DECISION DELEGATED TO DEVELOPMENT MANAGER

Application No: H03-0096-21 **Applicant:** Jelson Ltd.

Proposal: Erection of 66 dwellings and associated works - approved under H03-0599-20. Modification of Condition 1 to allow amendments to previously approved plans (substitute of house type on plots 49-56 & 61-62) and alterations to the Drainage Detail Plan

Location: Caultons Field West Of Littleworth Drove Deeping St Nicholas Spalding

Total Internal Area (GIA) Each House for Planning

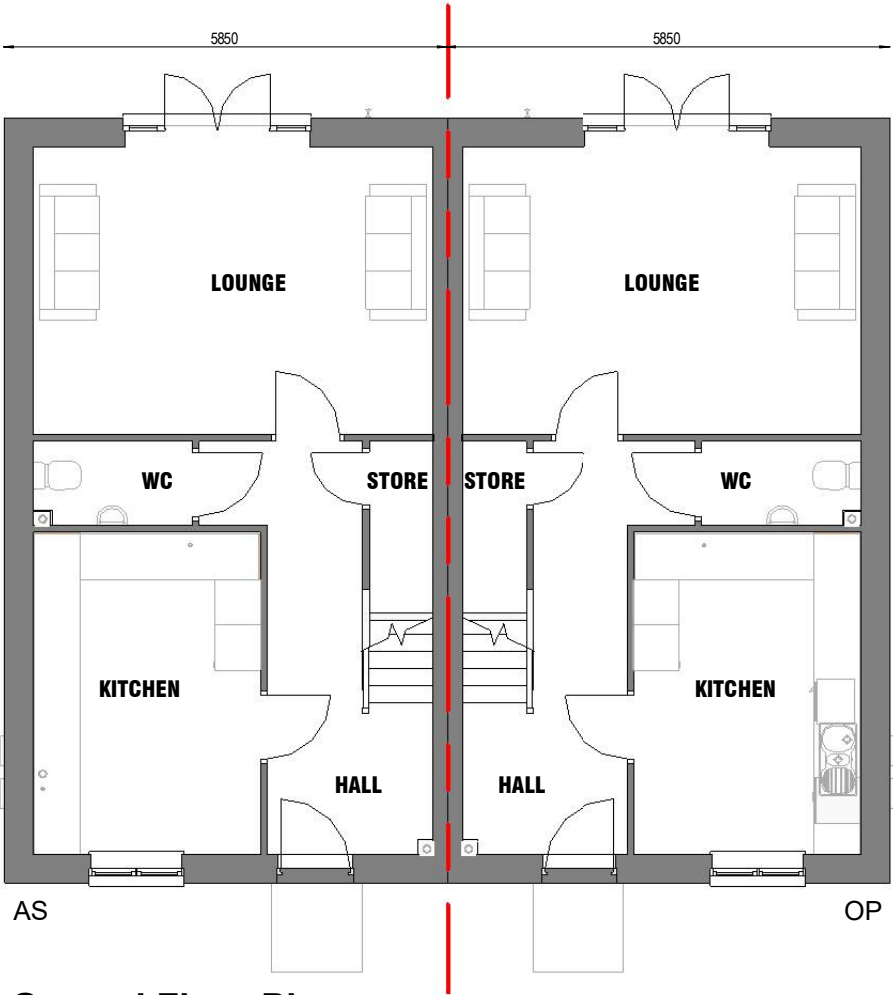
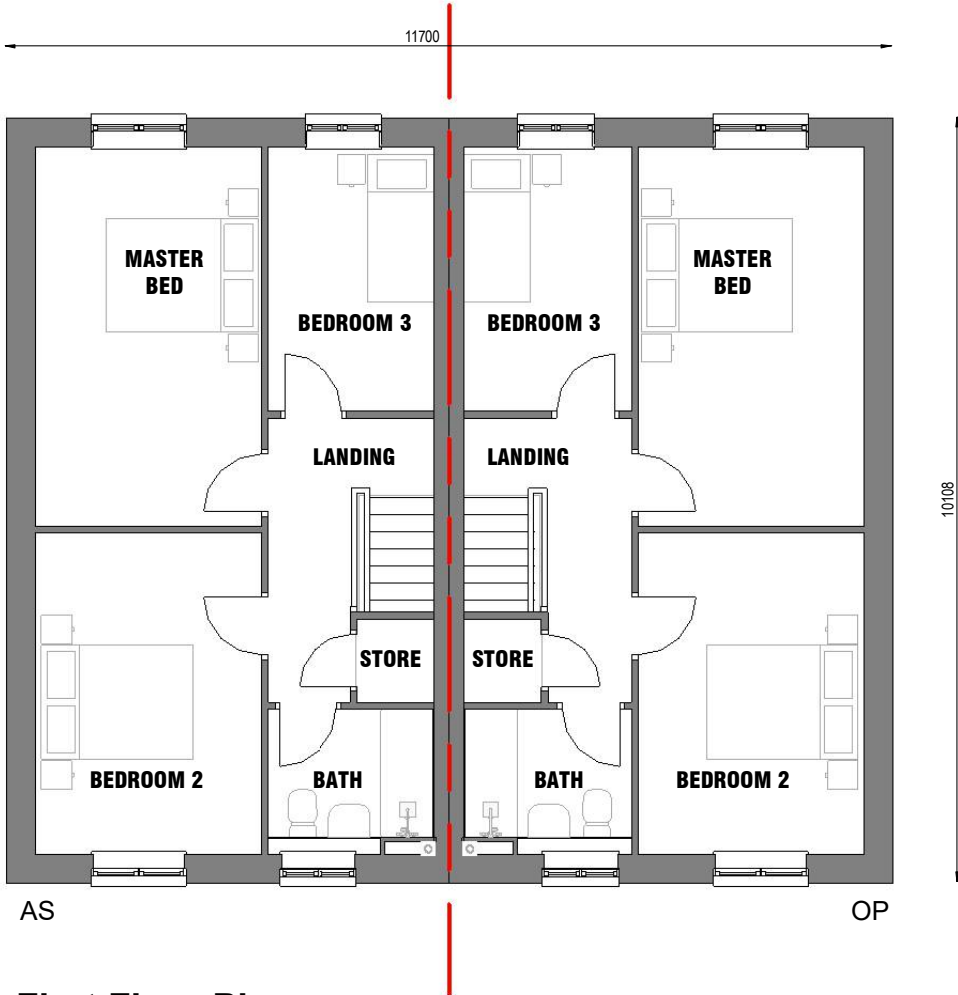
I can see these amendments relate to some of the affordable plots, and the application form states that the amendments ensures that the housing association plots are space standard compliant. However, it is not apparent what internal space sizes are now being proposed, and how different these are from the previously permitted plans. Can we please ask the applicant to advise.

OFFICER NOTE: Dimensioned drawings were submitted on 14 May 2021.
